# V5\_Drainage letter\_comments.pdf Markup Summary

**FINAL DRAINAGE REPORT  
LOT 2, BENT GRASS EAST COMMERCIAL FILING NO. 4  
CARUBIA PROPERTIES**

PCD FILE NO. PPR256

JUNE 19, 2025

DATE: JUNE 19, 2025
SCALE: AS INDICATED
DRAWN BY: JWD
CHECKED BY: JWD
PROJECT NUMBER: 2024-019
SHEET: C5.13
U/A - RPA EXHIBIT

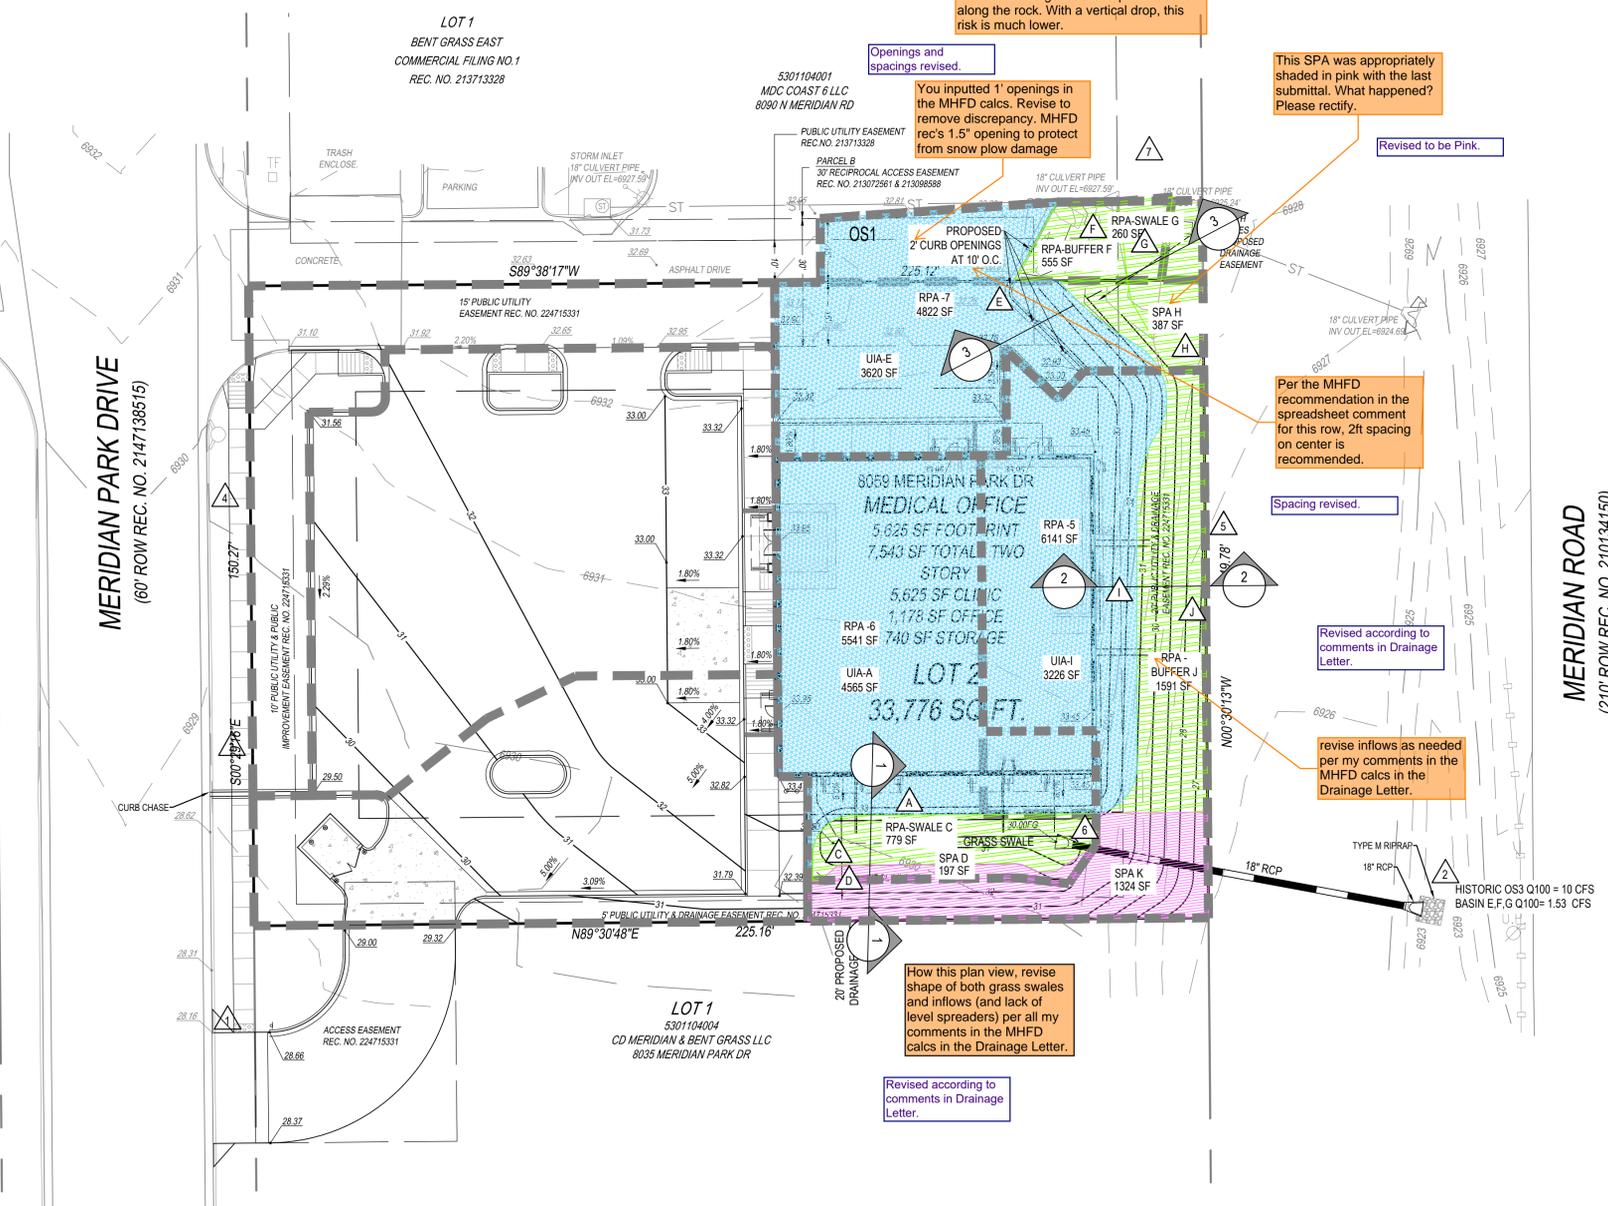
Please update this sheet per all of my comments in the duplicate sheet in the CDs.
